STATE OF NORTH CAROLINA
DEPARTMENT OF TRANSPORTATION

September 10, 2015

Subject: **Modification Request for Section 404 Nationwide Permit 23, Section 10 Permit, CAMA Major Development Permit, and Section 401 Water Quality Certification** for proposed widening of the US 17-74-76/NC 133 from the NC 133/SR 1472 Interchange to the US 421/NC 133 Interchange, Brunswick County. Federal Aid Project No. NHS-0017(68); TIP No. R-3601.

The purpose of this letter is to request modification and/or a letter of refinement of the issued permits on this project to accommodate construction of the temporary work bridge on the south side of Structure 107. Please find enclosed the revised permit drawing sheets 28, 29 and 44 for the above referenced project.

Revised  
9/20/15  
sdm

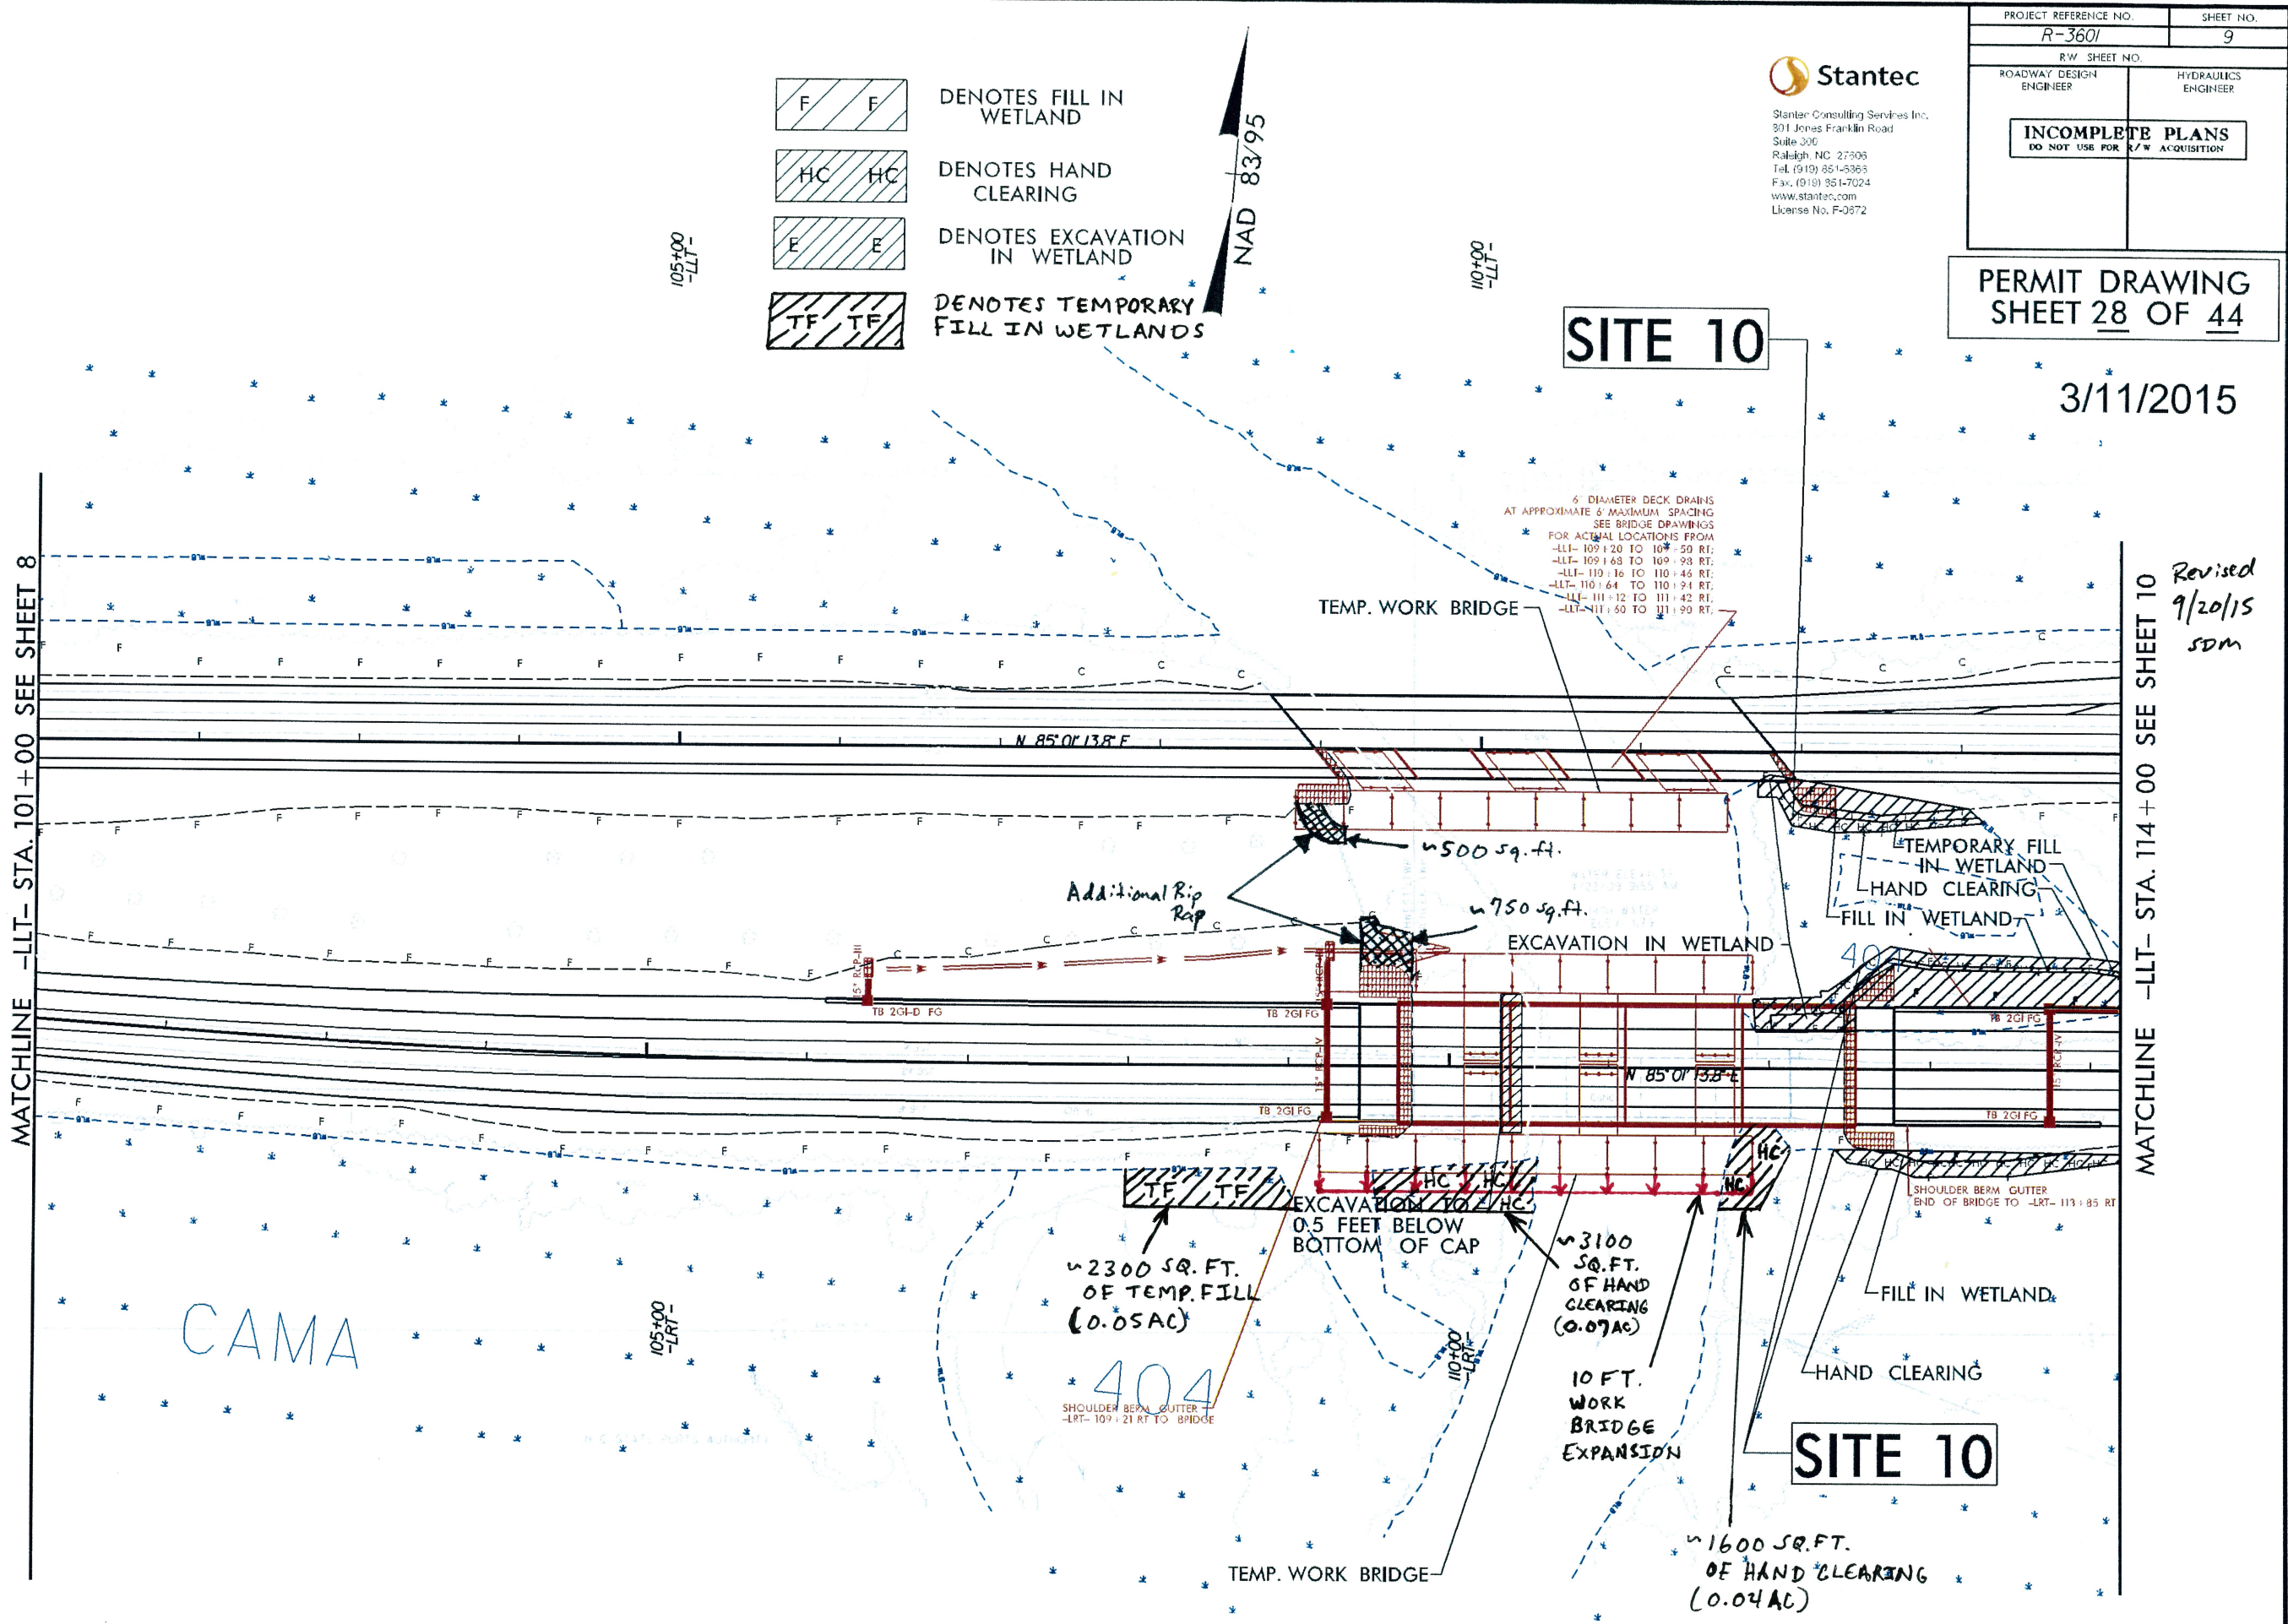
The contractor has determined an additional 0.02 acre of temporary fill is necessary to create a causeway for work bridge access at site 10. In addition, approximately 0.04 acre of hand clearing will be required for construction of the work bridge.
